From: Rachel . <blparishclerk@outlook.com>
Sent: Friday, April 7, 2023 10:20 AM
To: Planning <planning@ribblevalley.gov.uk>
Subject: 3/2023/0178

Following consultation with all members of the parish council, the following objections were raised:-

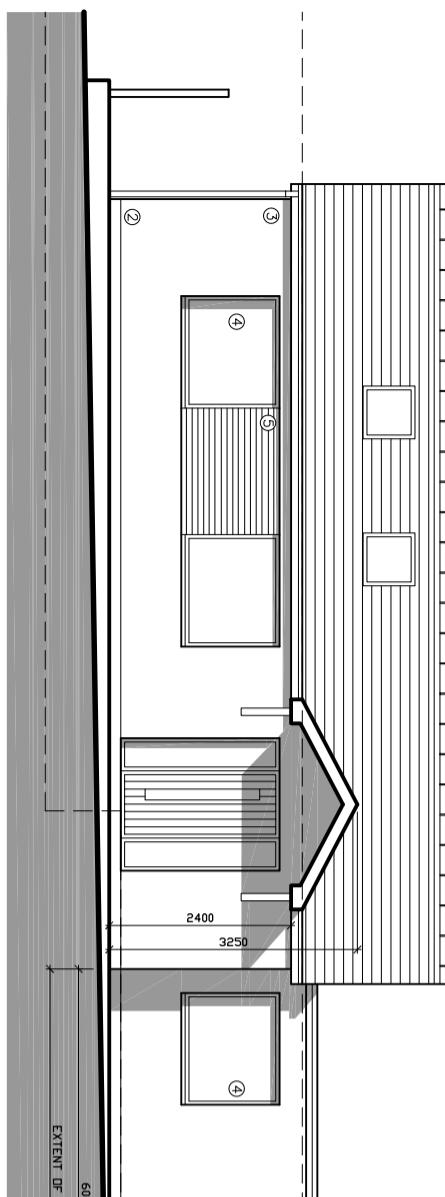
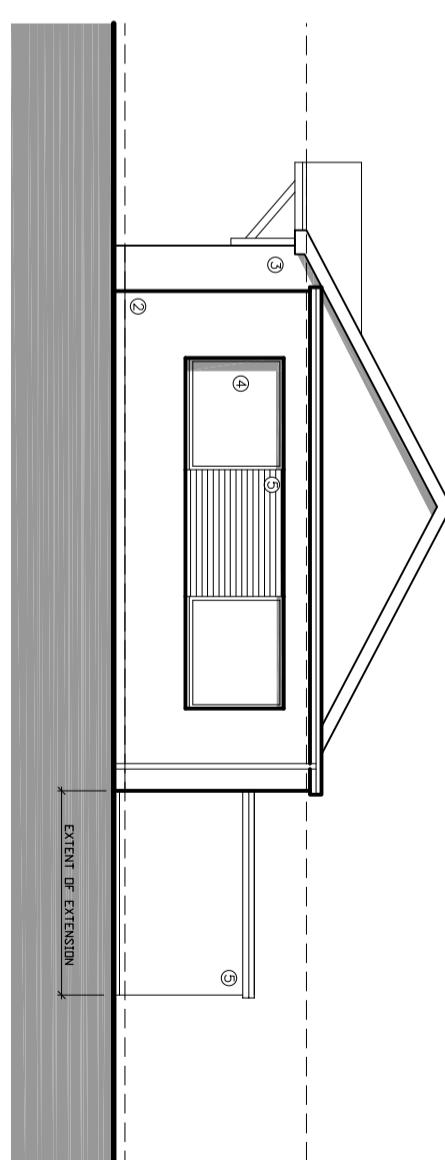
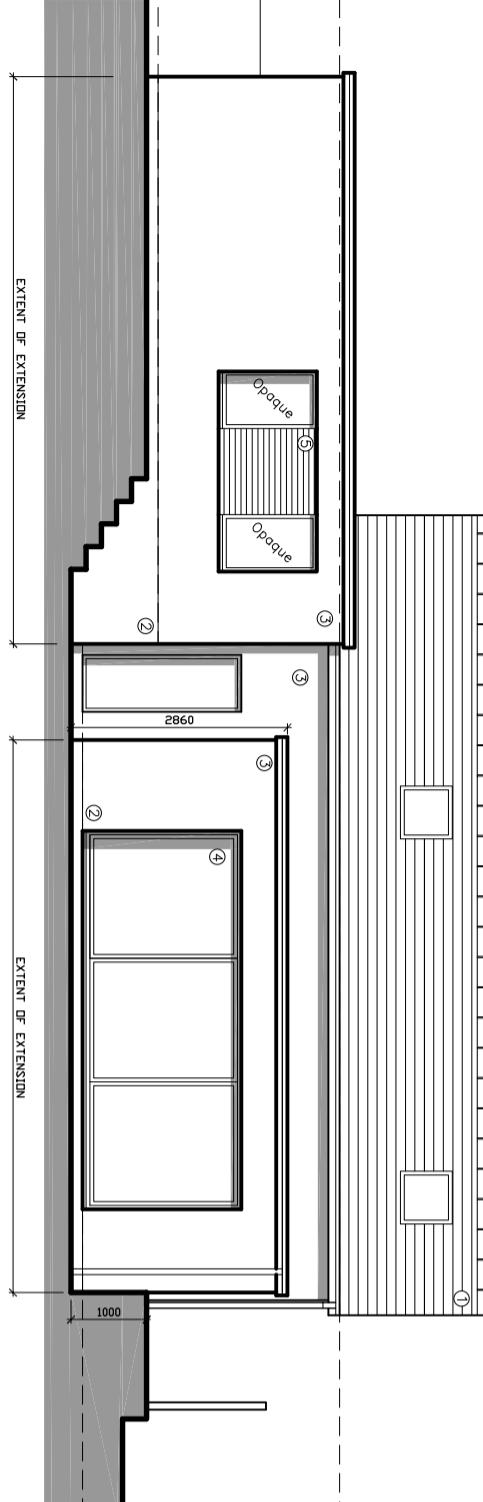
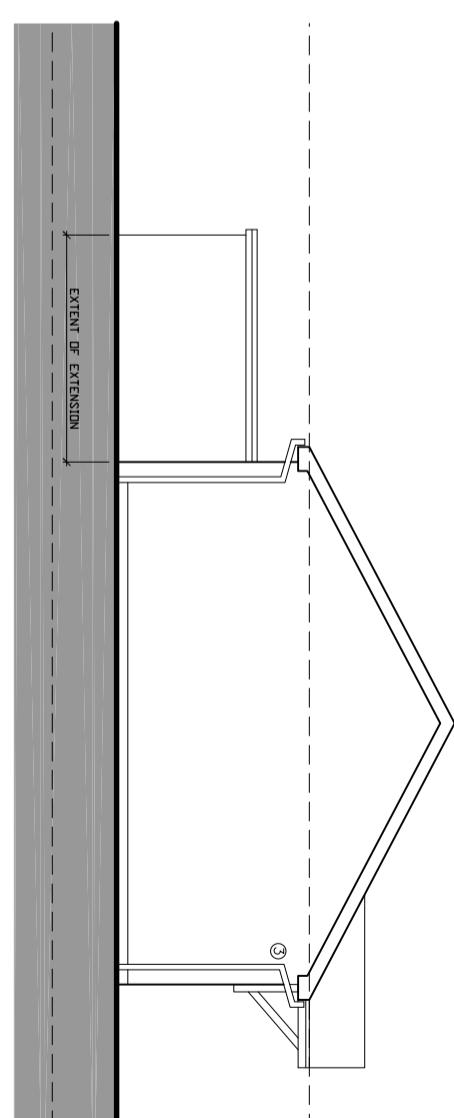
- 1 The proposed development, as a result of its design and proximity to a shared boundary, would lead to overlooking of the rear conservatory and garden area of No. 3 Moorland Road leading to a loss of privacy and sense of enclosure which in turn would be unduly harmful to the amenity of the neighbouring occupants. Accordingly, the proposed development is considered to be in conflict with Policy DMG1 of the Ribble Valley Core Strategy and Paragraphs 130 (e) and 134 of the NPPF.

- 2 The proposal is considered to be in conflict with Policies DMG1 and DMH5 of the Ribble Valley Core Strategy and Paragraph 130 of the NPPF in as much that the cumulative visual impact of the works proposed to the existing property would result in the introduction of an overbearing, unsympathetic and incongruous form of development that would be harmful to both the character of the host property and visual amenities of the area.

It was proposed that the above objections still stood as nothing had changed on the application.
